PLAN REVIEW SHEET

Petition #: RZP 2020-062

Address: Old Statesville Road and Gibbon Road

Request: I-2 (CD)/R-3 to B-2 and R-8MF

SHEET NUMBER
RZ-1

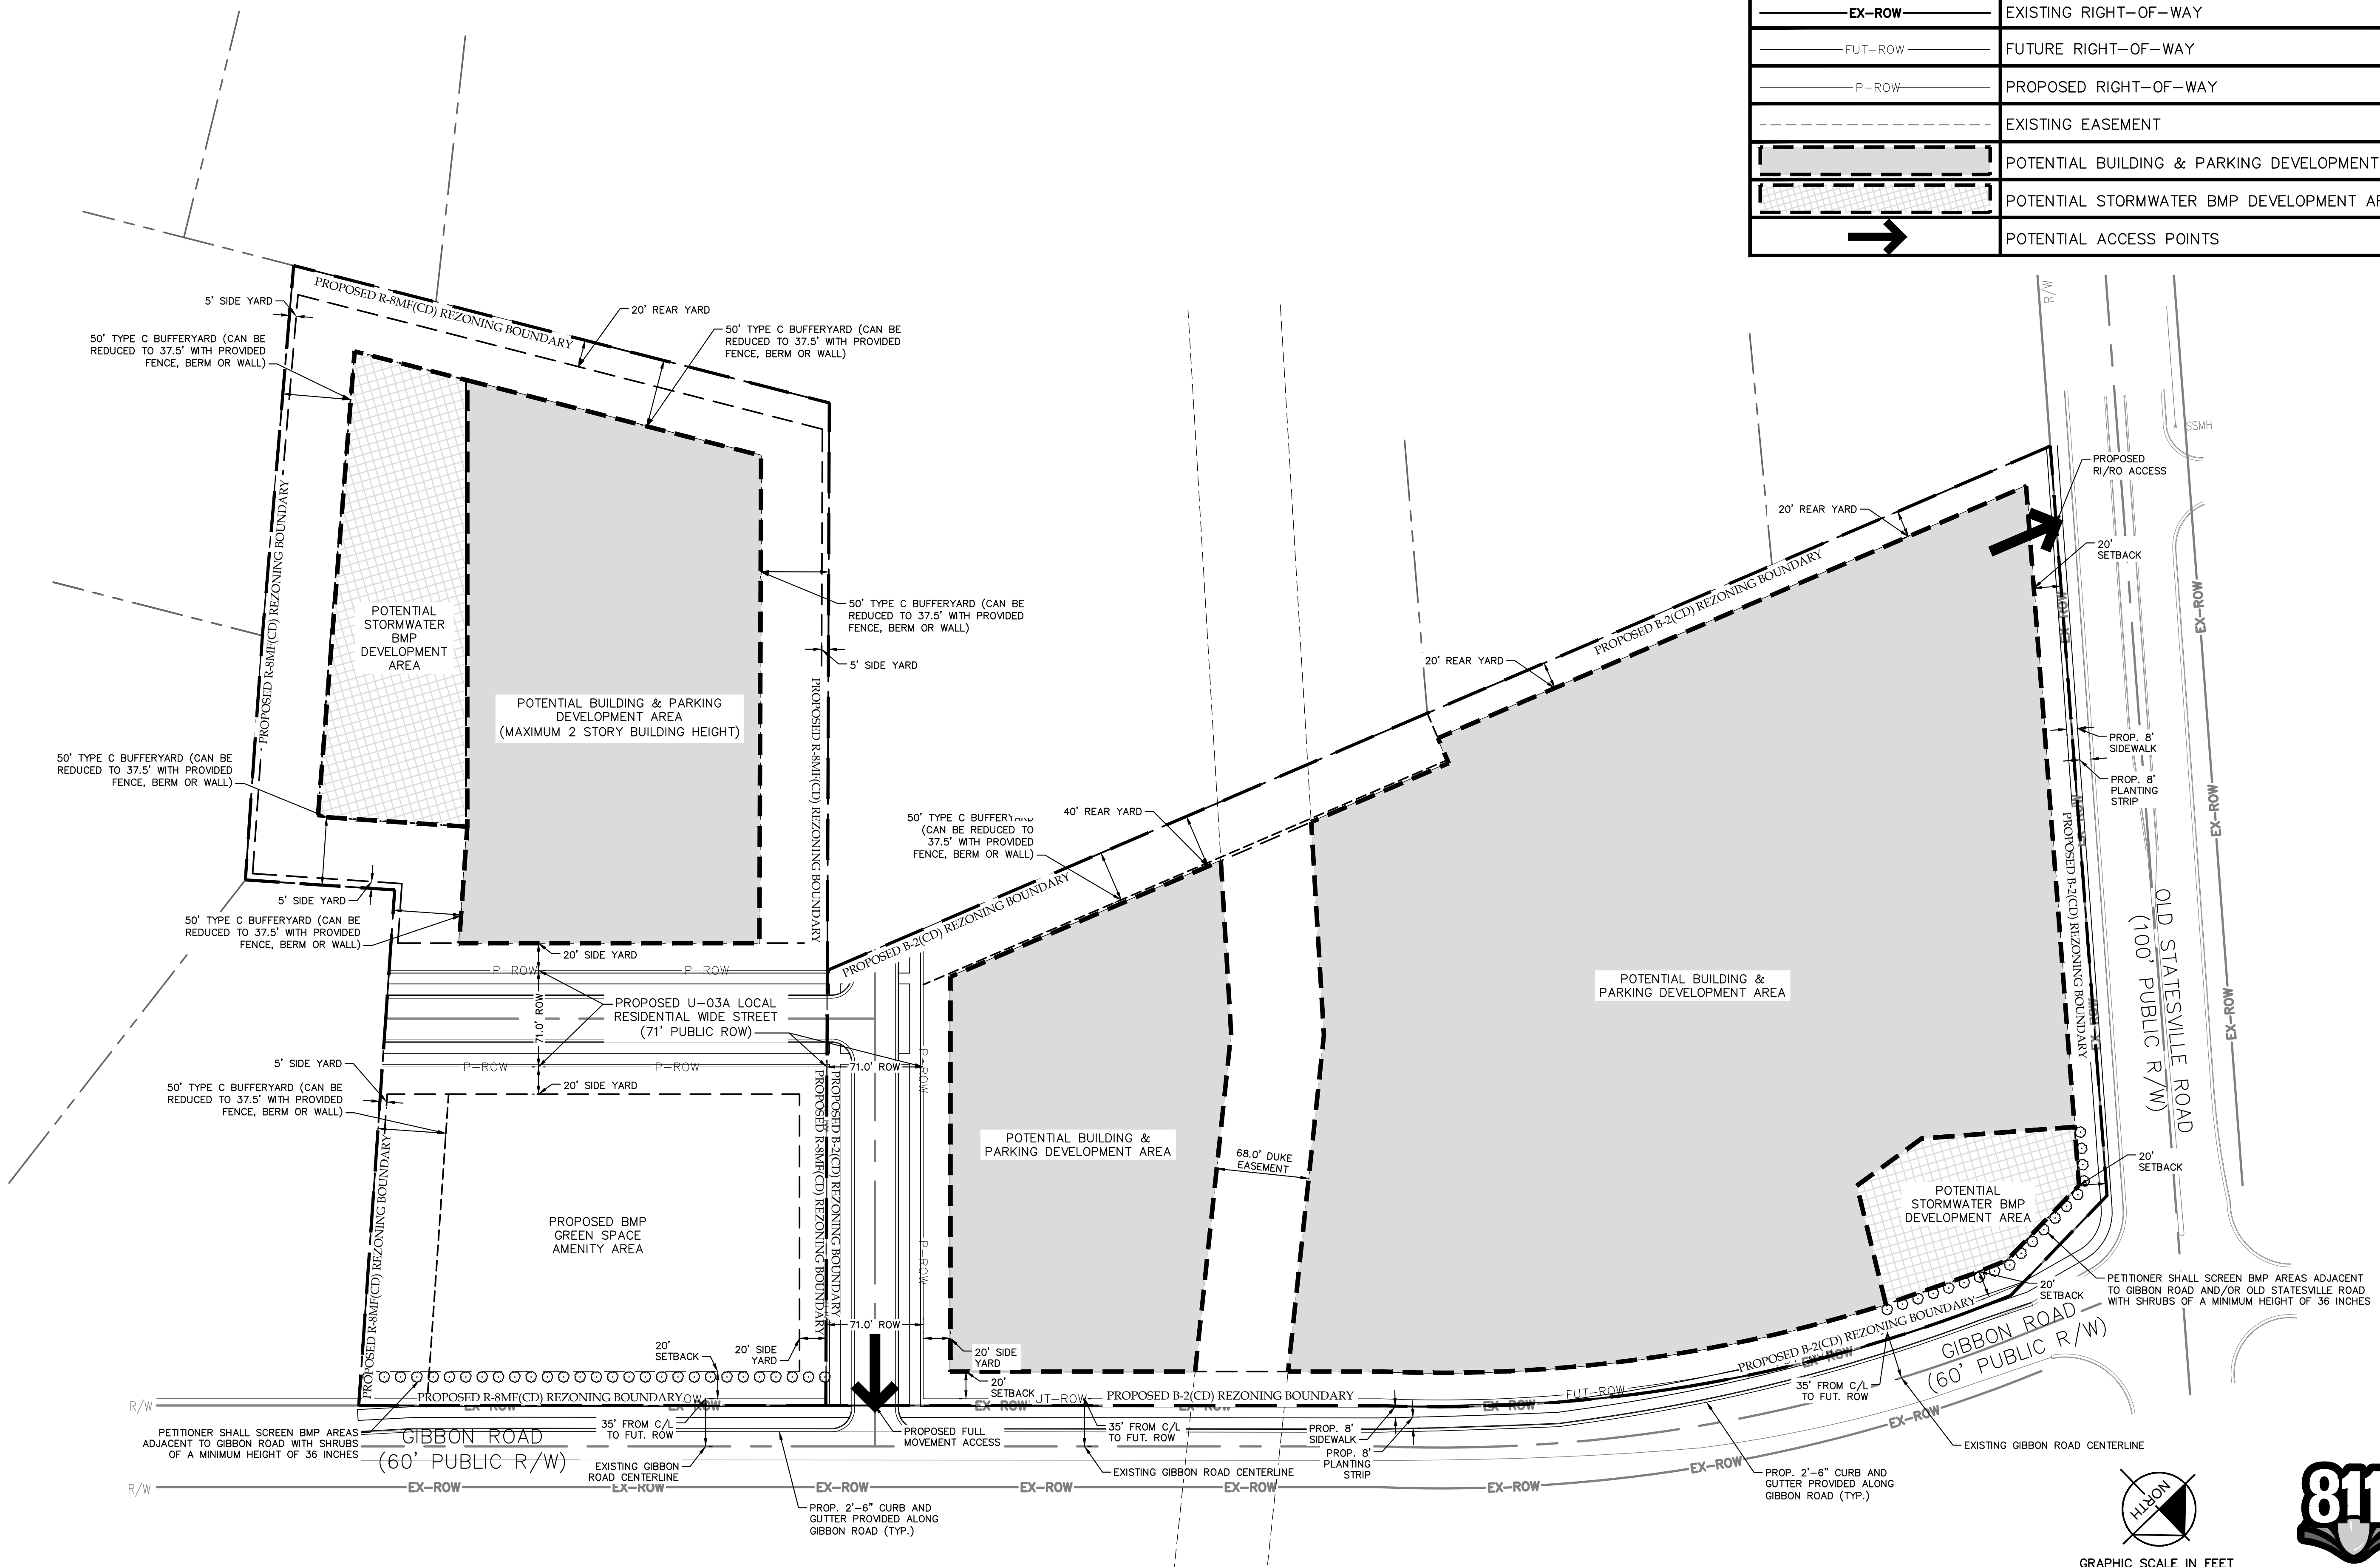
The site is located along CATS local bus route #21 along Old Statesville Road. CATS requests the petitioner to construct a standard ADA compliant bus waiting pad and shelter per Land Development Standard #60.01A along Old Statesville Road to replace the existing stop. The final location of the pad will be coordinated with the developer through the permitting process.
